From: Ian Gledhill [REDACTED]
Sent: 15 November 2018 09:44
To: Planning.Responses
Subject: RE: Planning Consultation on AL/122/18/DOC

APPLICATION NO: AL/122/18/DOC

Description of Works: Application for approval of details reserved by conditions 10 (Pedestrian & cycle access) & 13 (North bound bus stop) of AL/61/13/ (APP/C3810/A/14/2217385)

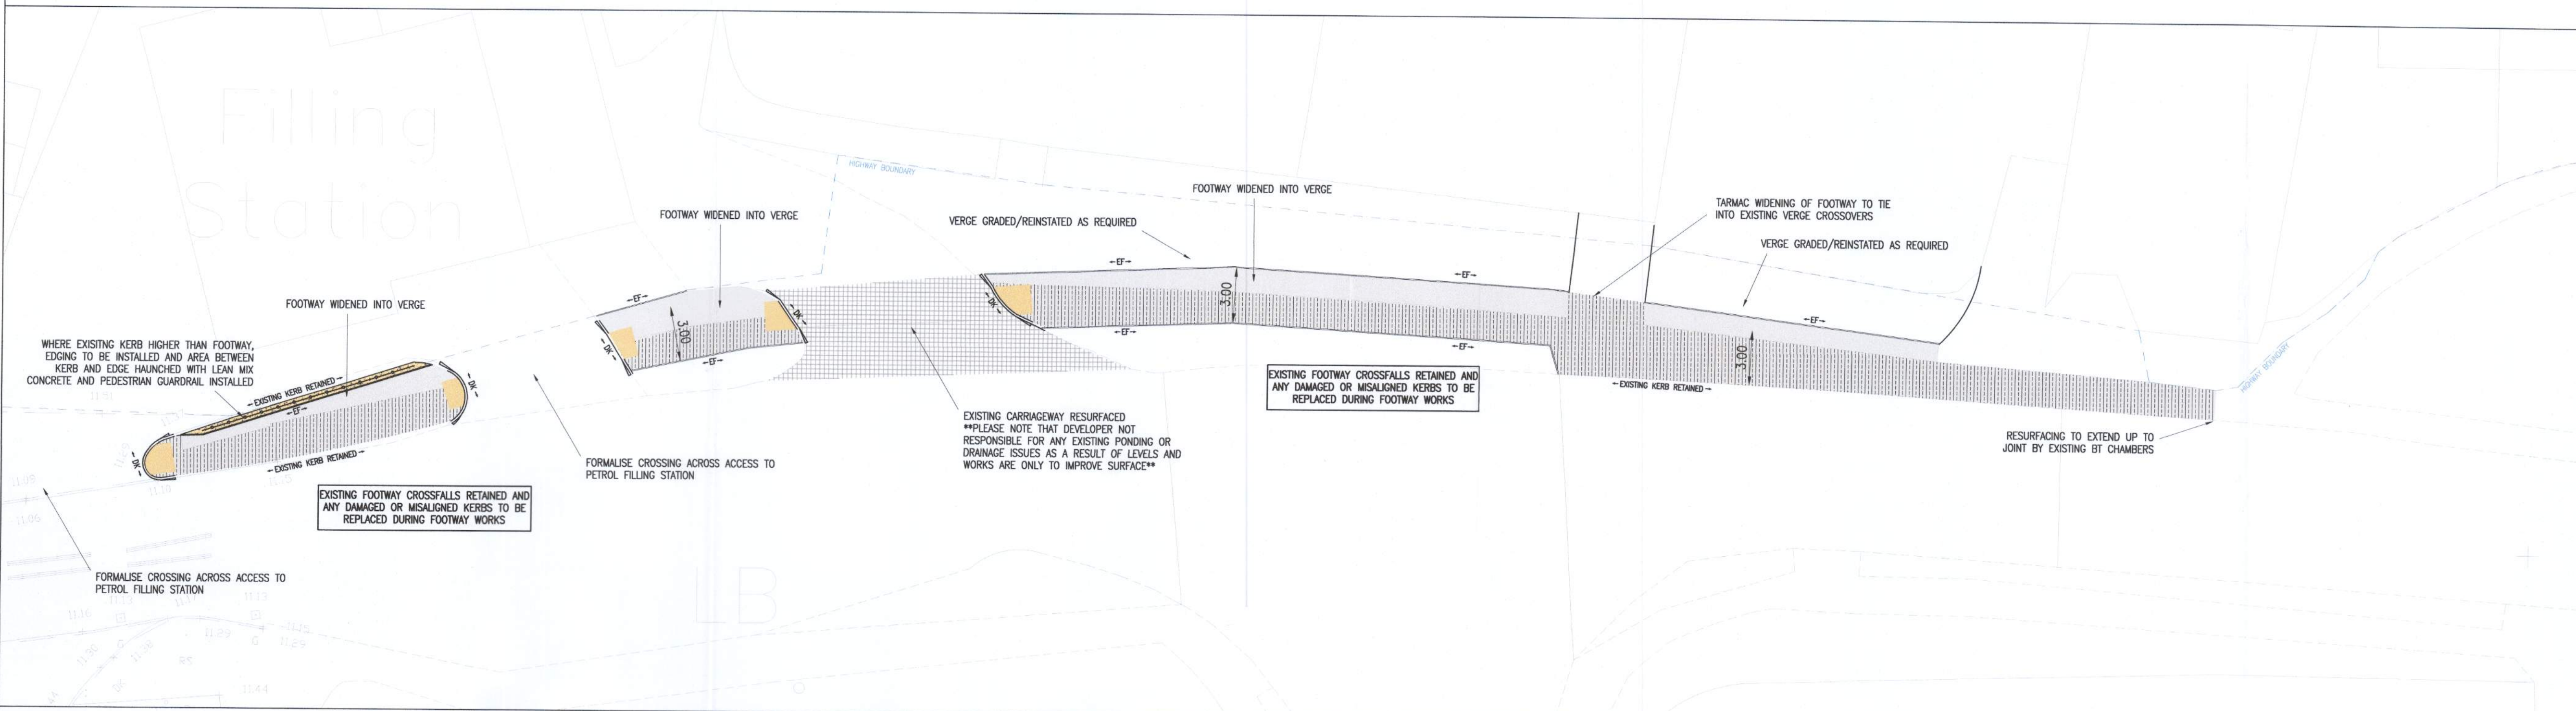
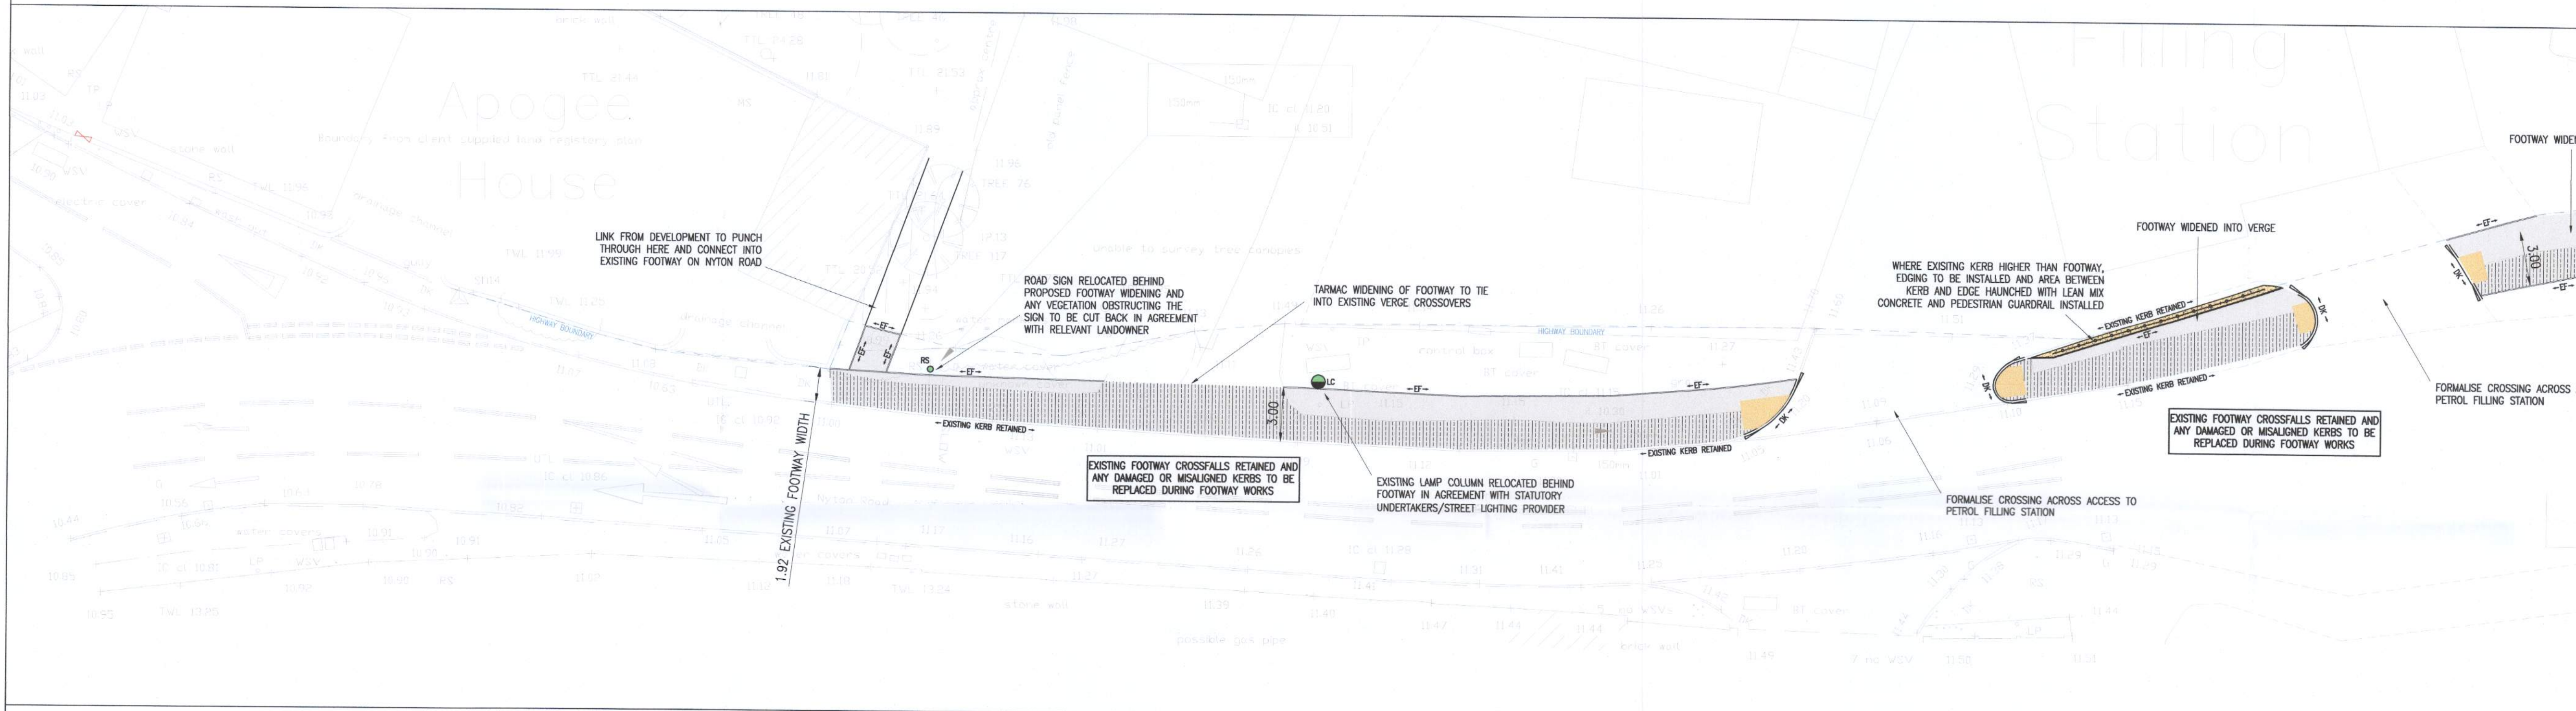
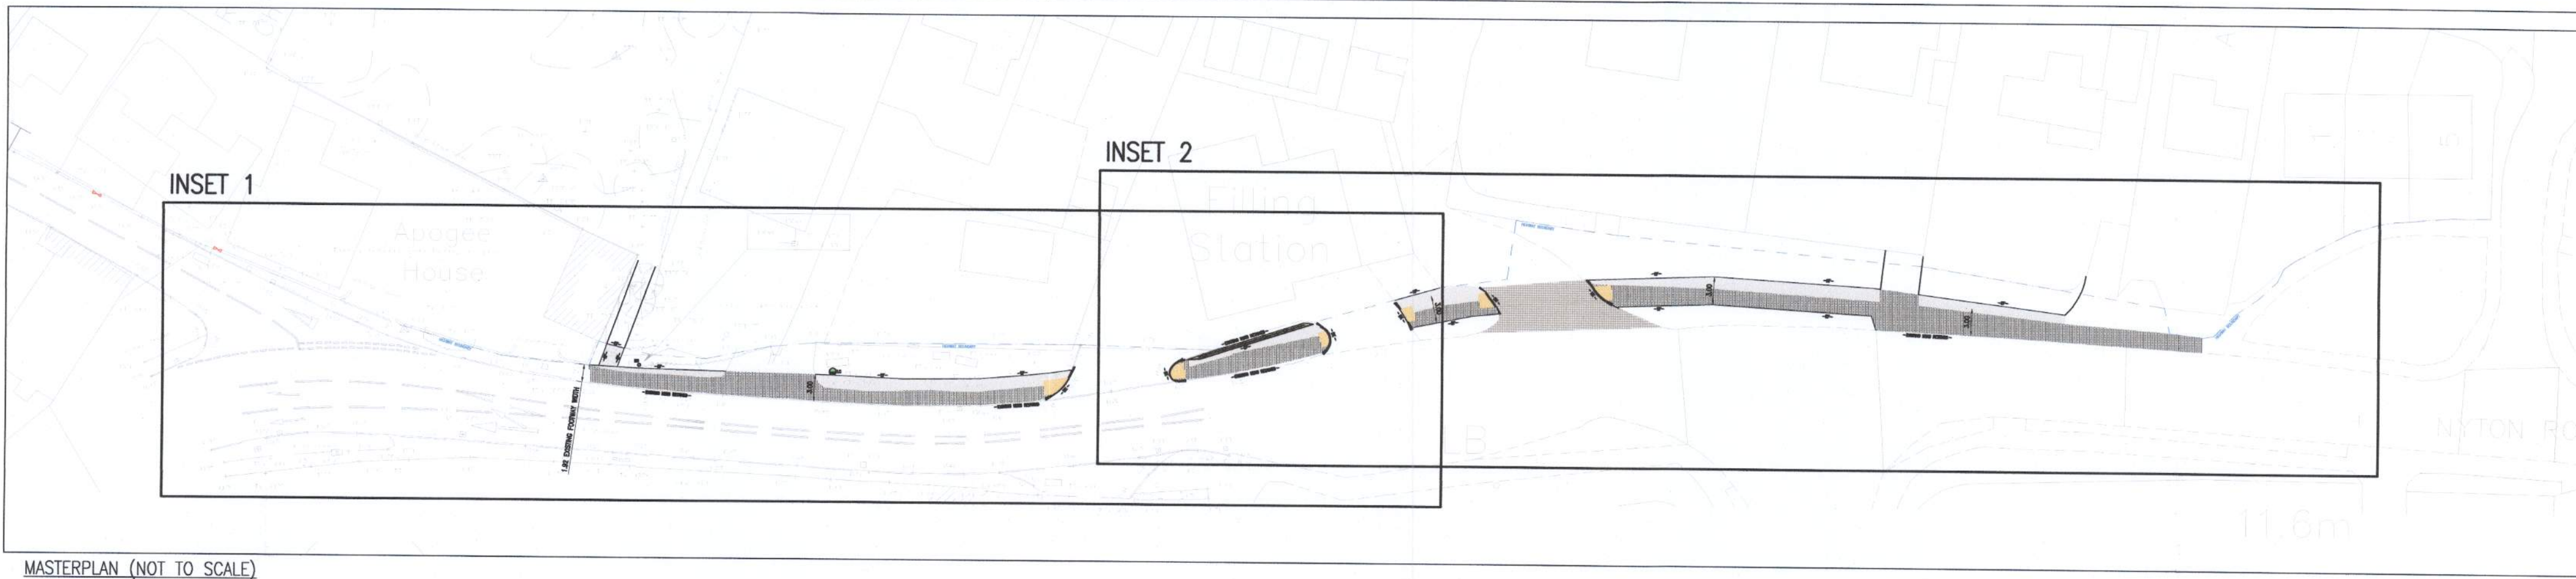
Condition 10 – Details are submitted showing the provision of a link onto the A29 Nyton Road adjacent to Apogee House. Associated with this link, a scheme of footway widening is proposed along the A29. These details accord with those accepted in principle as part of the outline planning permission. Those details submitted are accepted. As a further comment, the condition does also refer to details for the link onto Northfields Lane. No details are submitted in connection with this. In saying this, Northfields Lane does not form part of the adopted highway network. The permission of WSCC would not be required to undertake any works to this. It's also understood (from the outline consent) that the access to be used is existing and has previously been used as part of the former nursery that occupied the site. No works may consequently be proposed. The Local Planning Authority may wish to confirm this with the applicant. WSCC are though satisfied that the details submitted fulfil the condition. Condition 10 can therefore be discharged.
